From: Kerri Simpson
Sent: 07 May 2026 10:56
To: DC Admin
Cc: Faiza Bano; Sarah Longbottom
Subject: FW: Planning Objection Conformation FS-Case-824790118
Attachments: A1 GROUPED.pdf; PROP SIDE.pdf; EX SIDE.pdf; PROPOSED.pdf; EXISTING.pdf; SITE PLAN.pdf

Please can the below comment and attached drawings and pictures be uploaded as an official comment of objection on the proposal application 2026/62/90765/E as discussed in the email trail, to add more details to our original objection.

**DRAWING TITLE**  
Site Location Plan and Proposed Site Plan

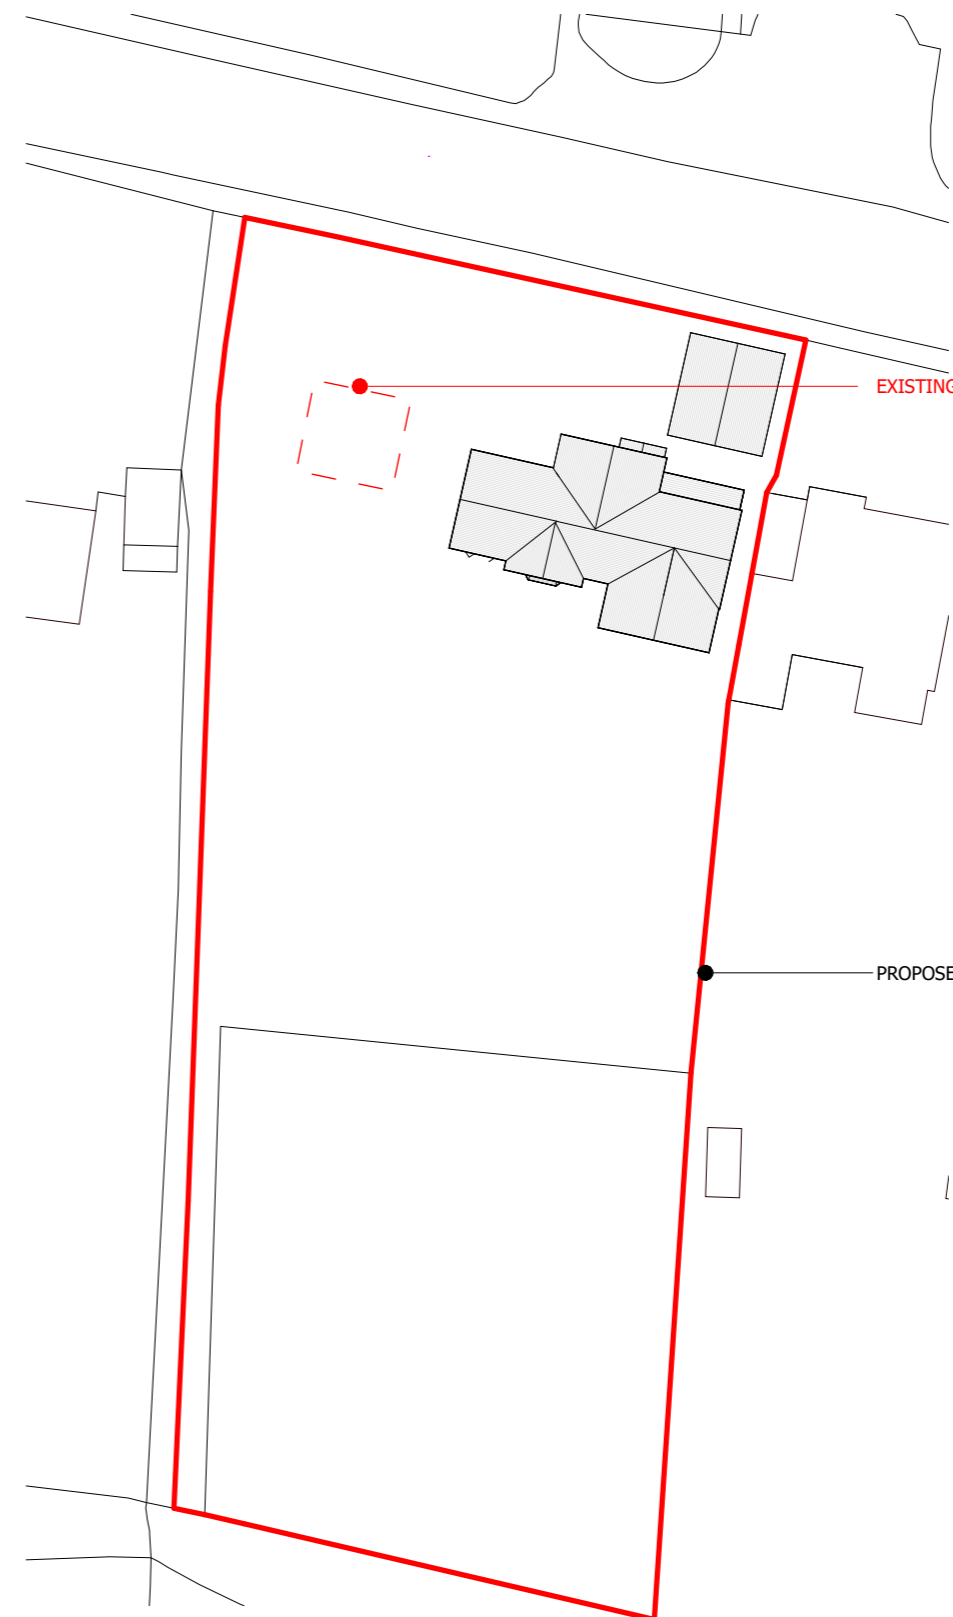
Also, I have not had any confirmation of whether the proposed double garage is an extra garage to be built in front of the existing dwelling, or a replacement for the existing double garage.

These drawings also highlight the size of the land available for the applicant to extend the dwelling on the south, west, and north side of the dwelling, without impacting neighbouring properties, or affecting the spacial and visual distance between the dwellings, and unnecessarily bulks most of the development to the East/319a side of the property, while leaving a very large space to the west of the dwelling, effectively leaving a very large garden space, on a plot already 2/3 of an acre, most of which is existing garden, when this could be used to sympathetically improve the dwelling and Green belt space. I would be very concerned that the proposal lends itself to future redevelopment of the land to the west side of the existing dwelling, especially with it being green belt.

The proposal does not visually improve the look of the property from the Halifax Road side, and adding another double garage in front of the dwelling diminishes the look further, and goes against planning guidelines. There is an existing well positioned double garage on the plot and ample space for parking, without impacting neighbouring properties.
